## KITTTITAS COUNTY COMMUNITY DEVELOPMENT SERVICES

### **RE: Easton Travel Center SEPA Checklist (SE-26-00001) – Deemed Incomplete**

Parcel #'s: 778834

**PRELIMINARY SITE PLAN**  
 MOUNTVIEW GROUP LLC TRAVEL CENTER  
 WEST SPARKS ROAD  
 EASTON, WASHINGTON

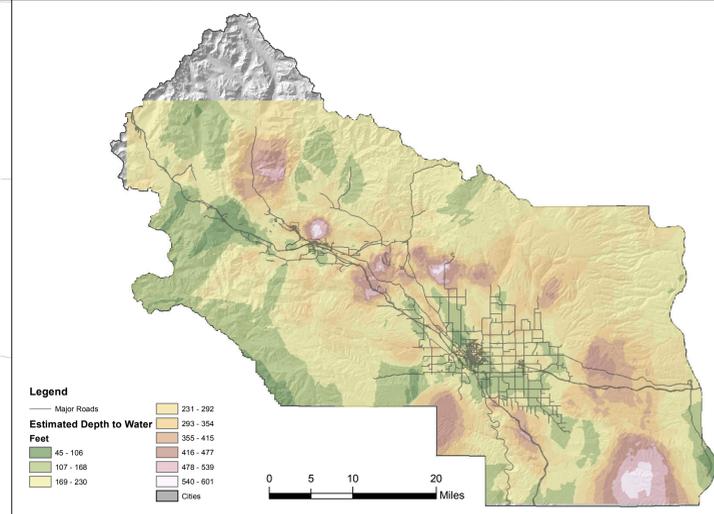
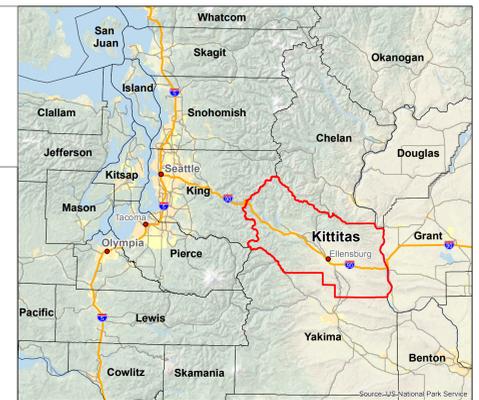
4. The CARA – Hydrogeologic Assessment report includes a site plan that does not match the site plan submitted with SE-26-00001 Easton Travel Center. Please submit an updated report with an accurate site plan that shows the proposed development.
